Bolney Parish Council would comment on the the following documents submitted by the Applicant to Deadline 3: Outline Landscape and Ecology Management Plan REP3-037 and Design and Access Statement REP3-013: In Commitment C-254 in the Commitment Register REP-049, the Applicant commits to a detailed landscaping plan to screen the extension to the National Grid substation.

Indicative Landscape Plan: AIS Option
Sheet 2 of 2

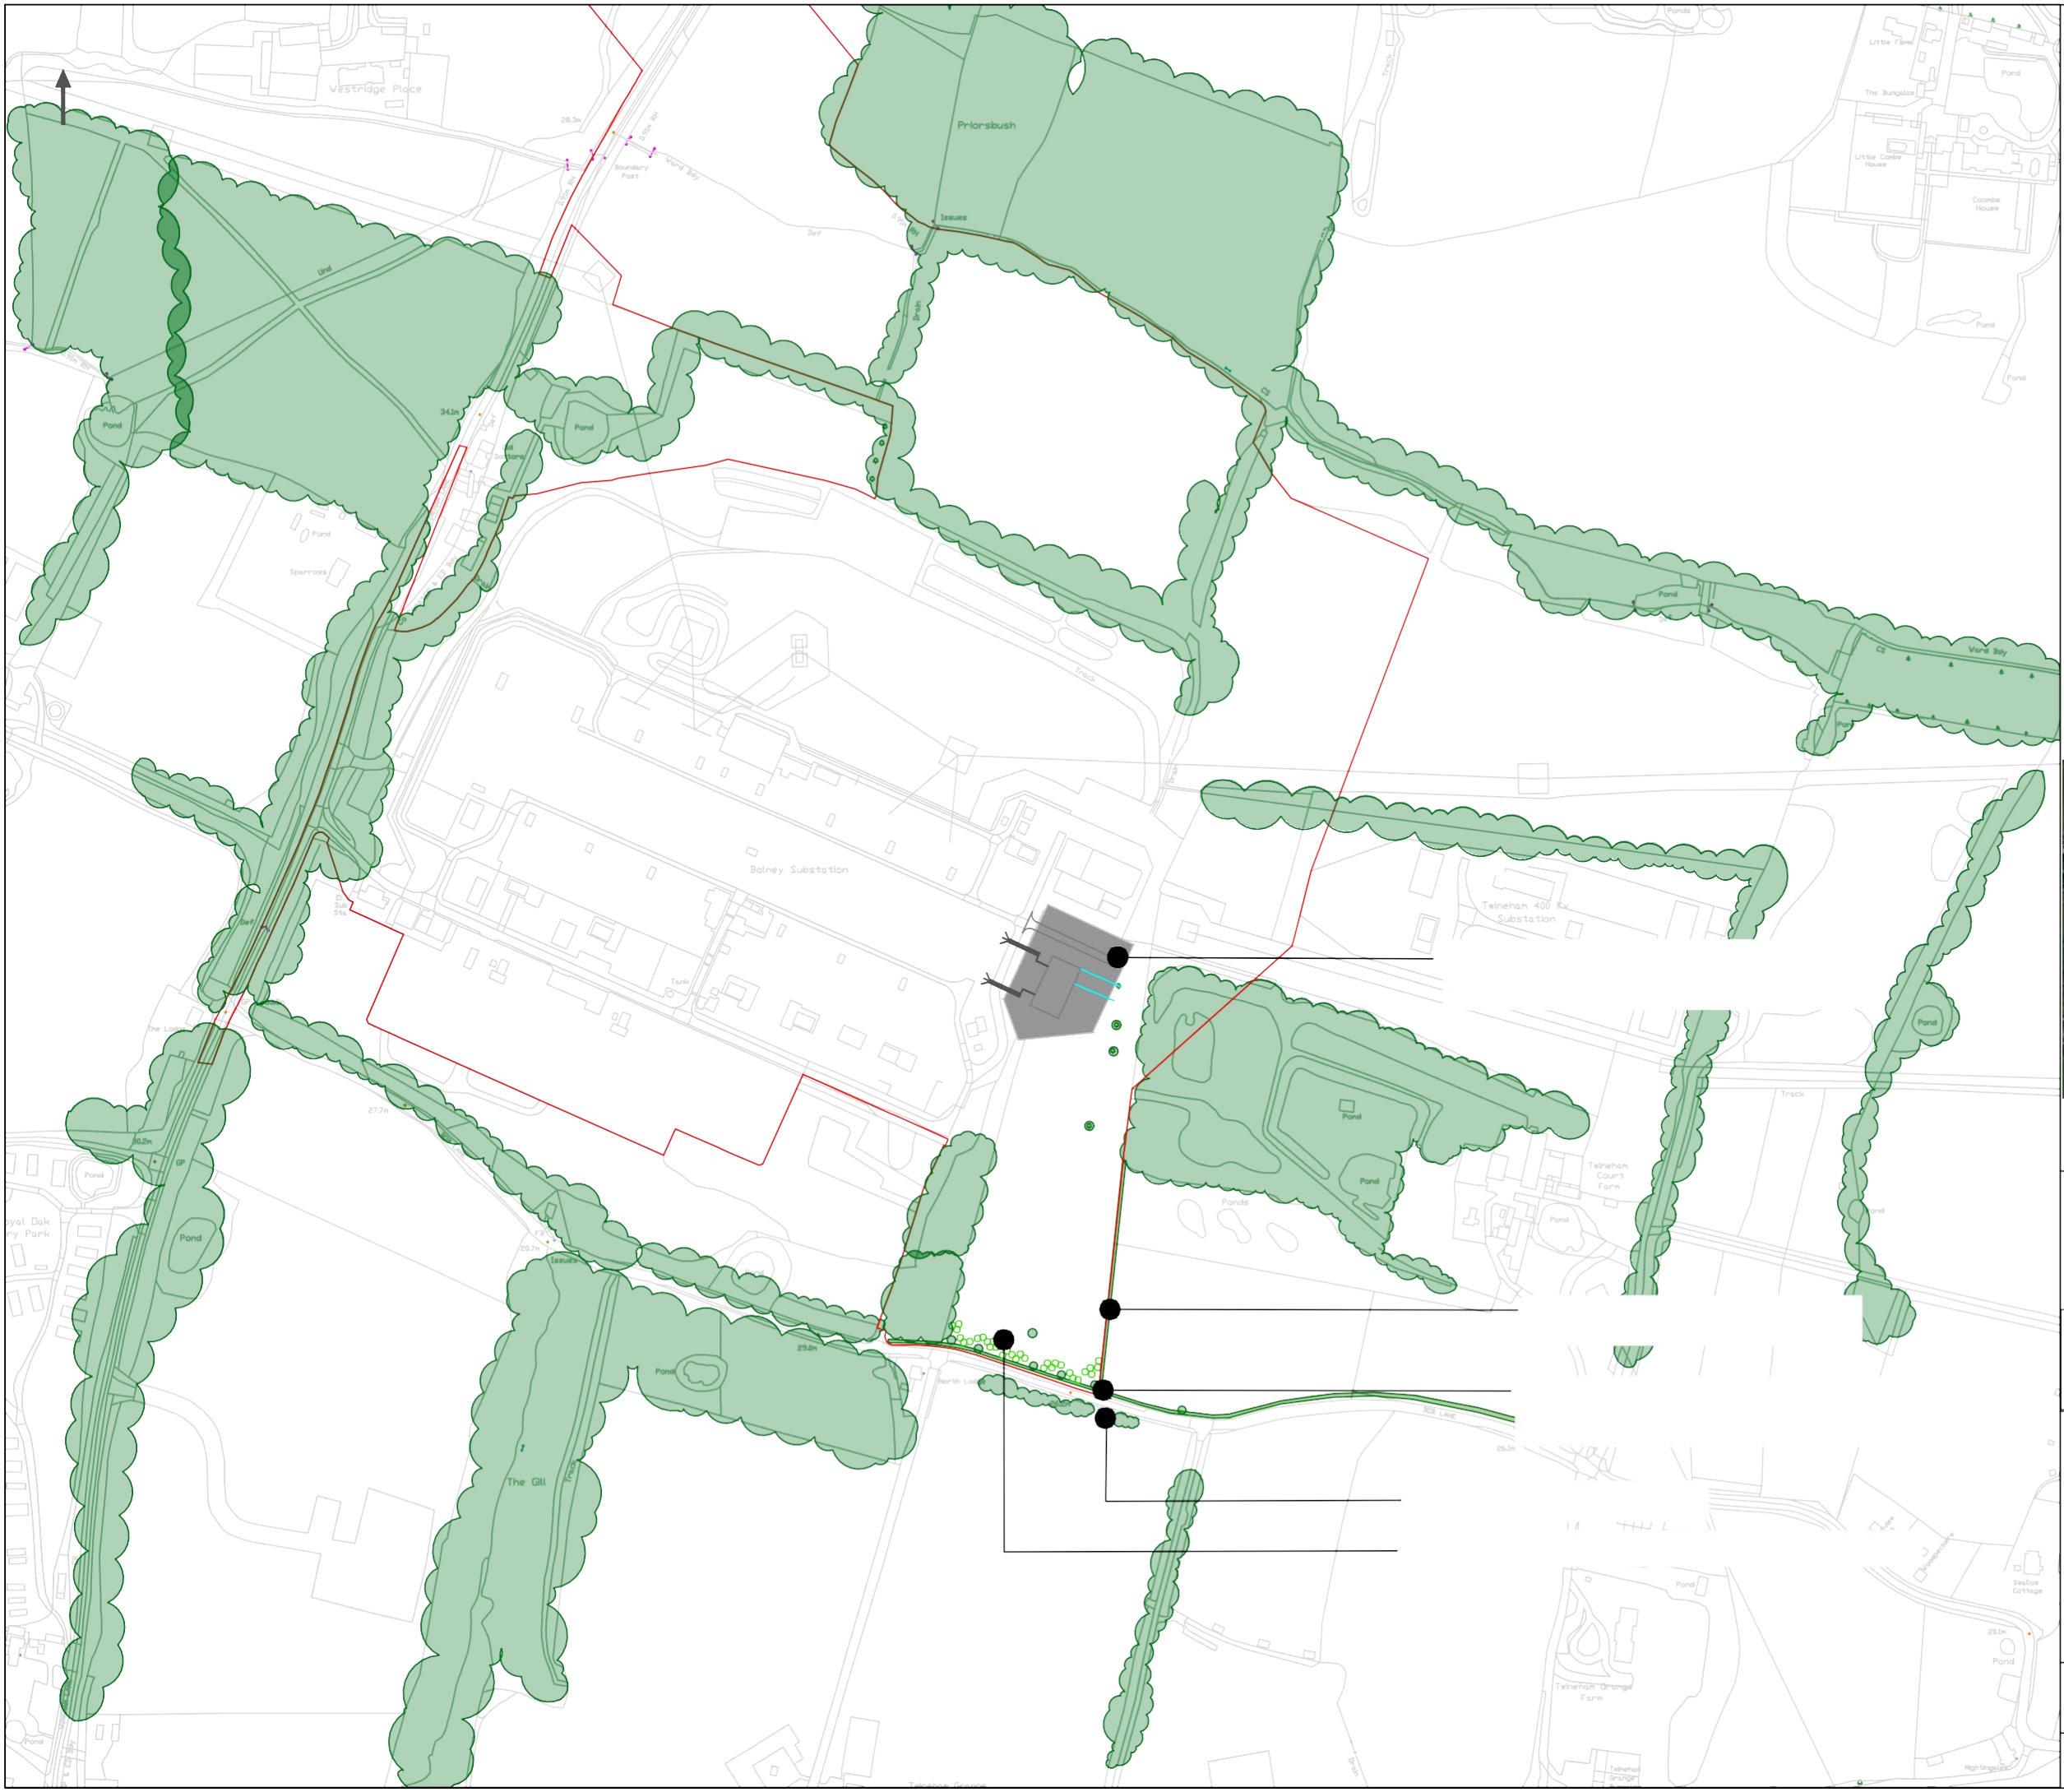
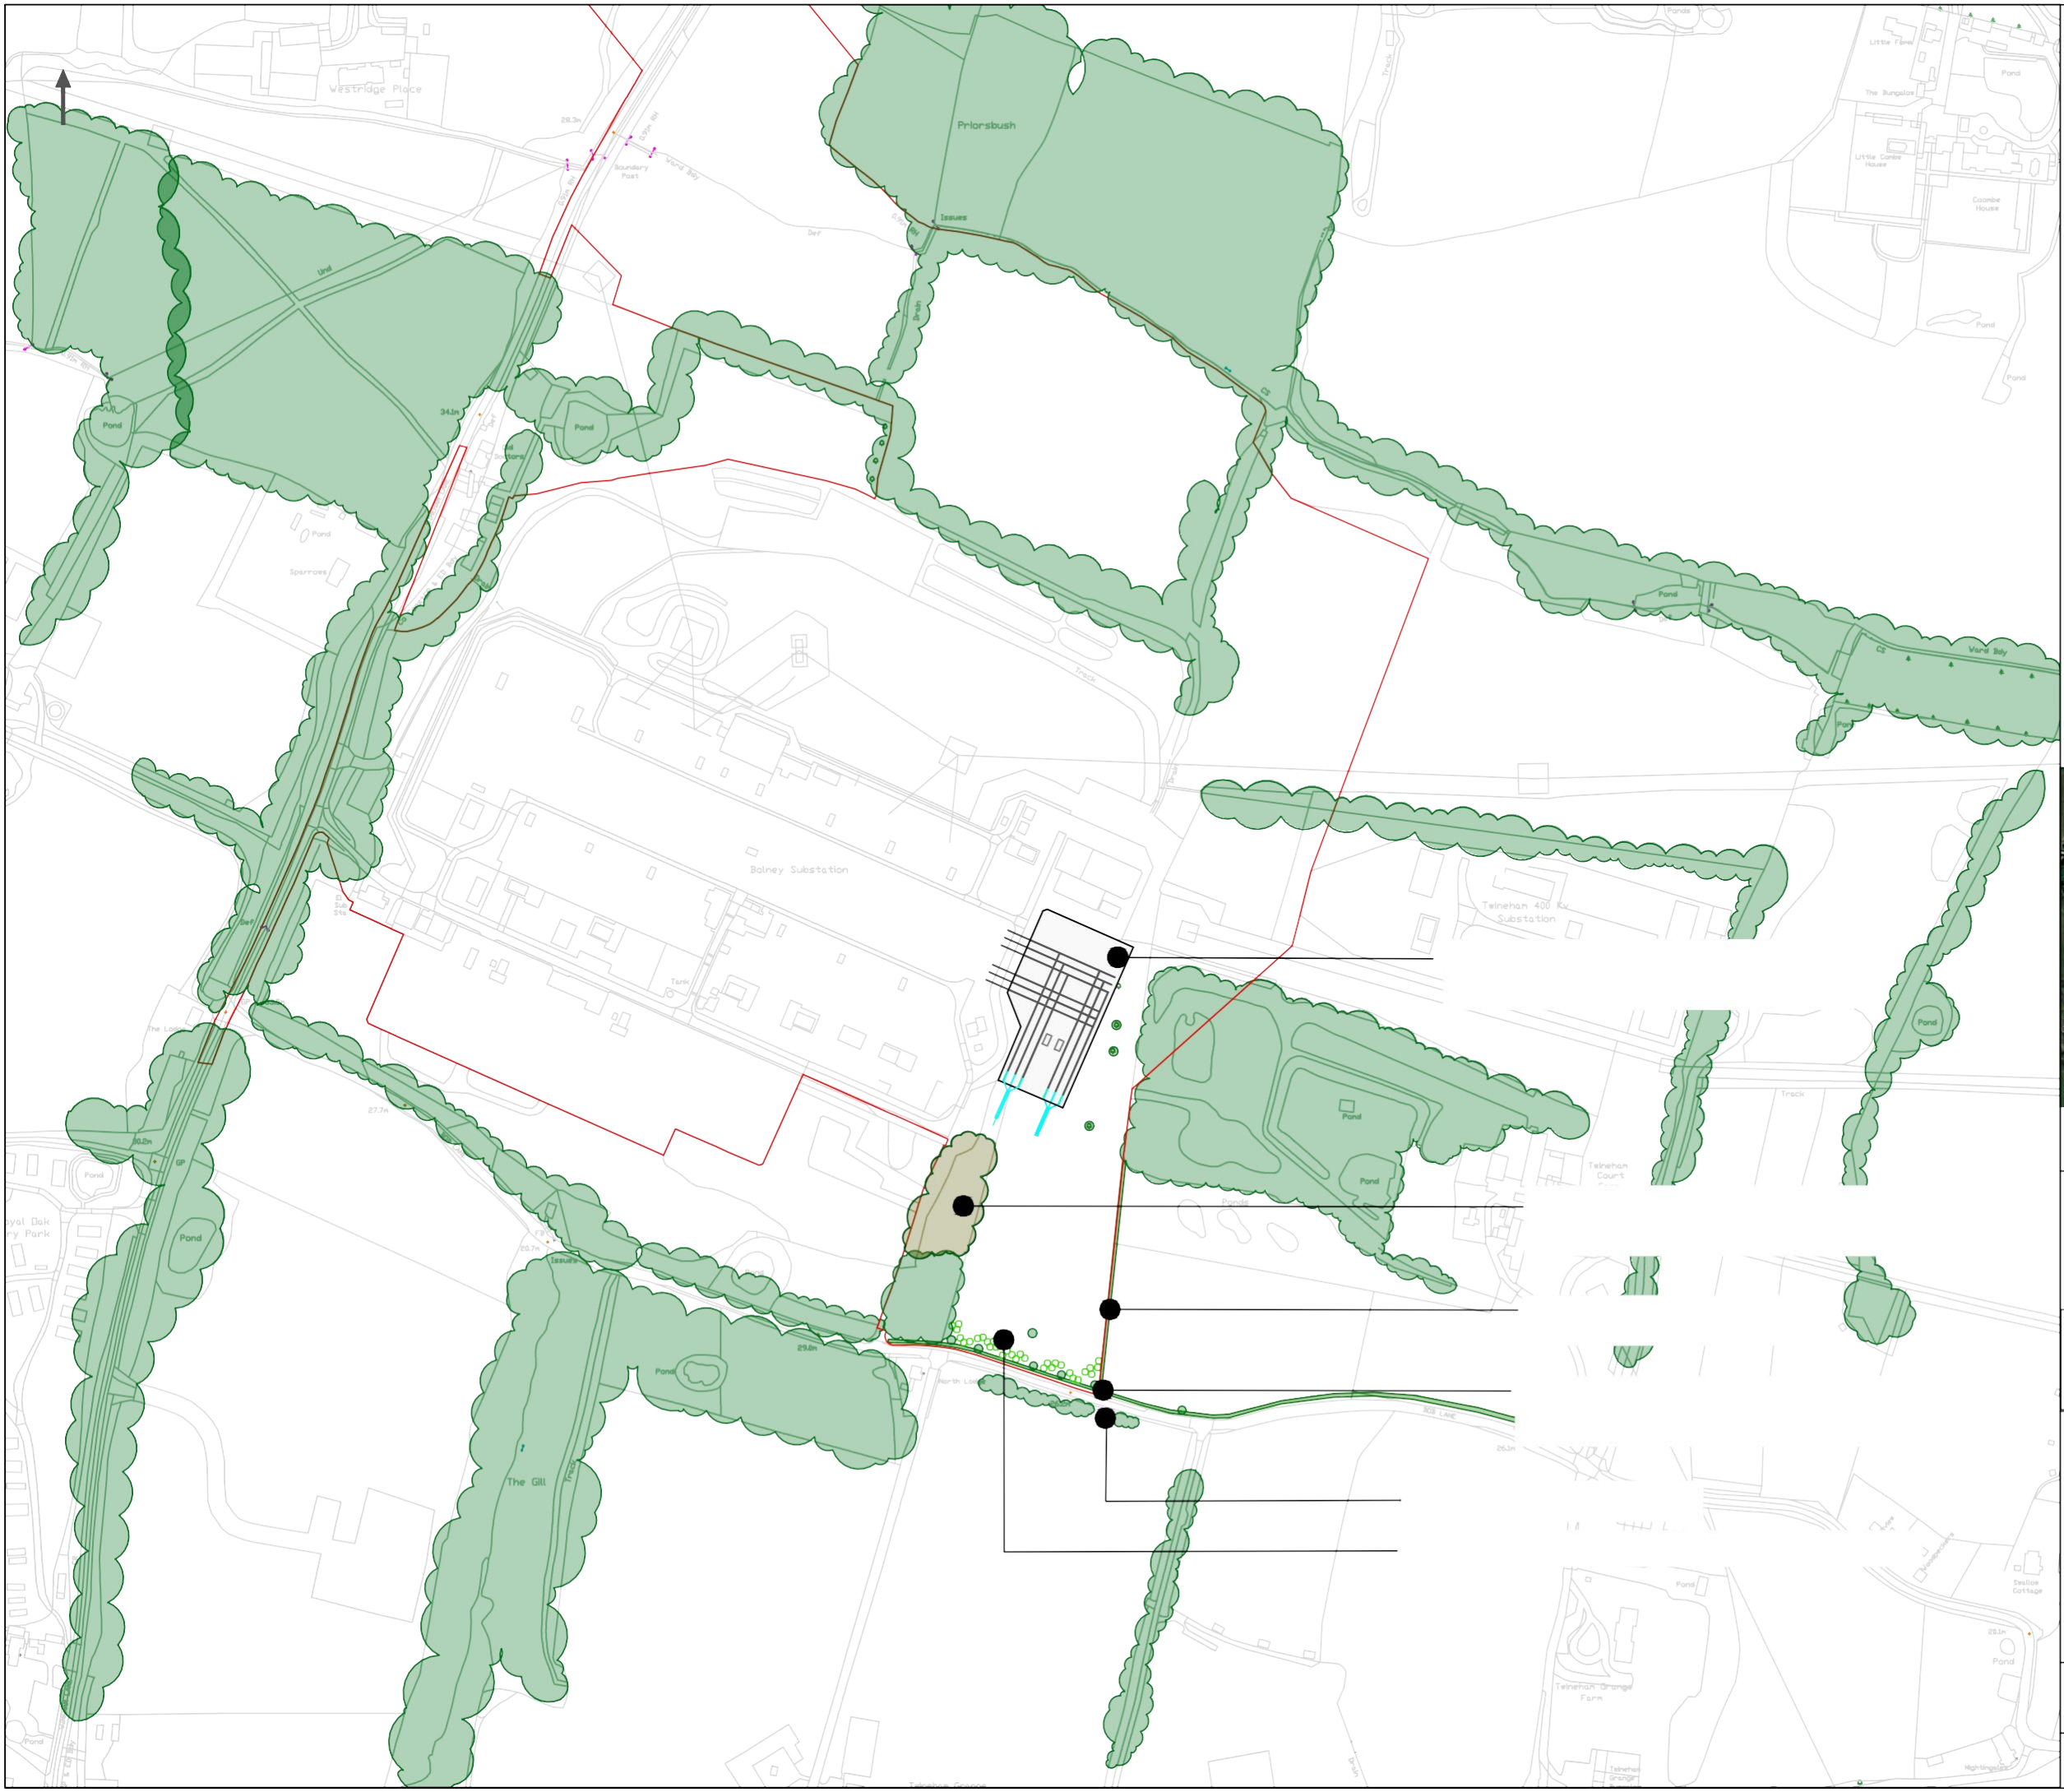
Despite the concerns expressed by MSDC and the Conservation Officer, the Applicant has failed to include any proposed landscaping to the north of the National Grid substation as demonstrated in Appendix C of the Design and Access Statement REP3-013 (showing the indicative landscaping plan for the GIS and AIS extension options) and the Outline Landscape and Ecology Management Plan REP3-037. This is despite the fact that a section of hedgerow, which currently helps screen the extension site from the Listed Building and other residential properties to the north, will potentially be removed to make way for the underground connecting cable from the new Rampion 2 substation at Oakendene and the National Grid substation extension. See Figure 7.2.6n in Appendix B to the Outline Code of Construction Practice REP3-025.

Bolney Parish Council asks that the Applicant revise the landscaping plan to ensure that it meets its Commitment C-256 and that its landscaping plans will adequately screen the extension of the National Grid substation from the nearby PRoW, Listed Building and residential properties to the north of the site in the Parish of Bolney.
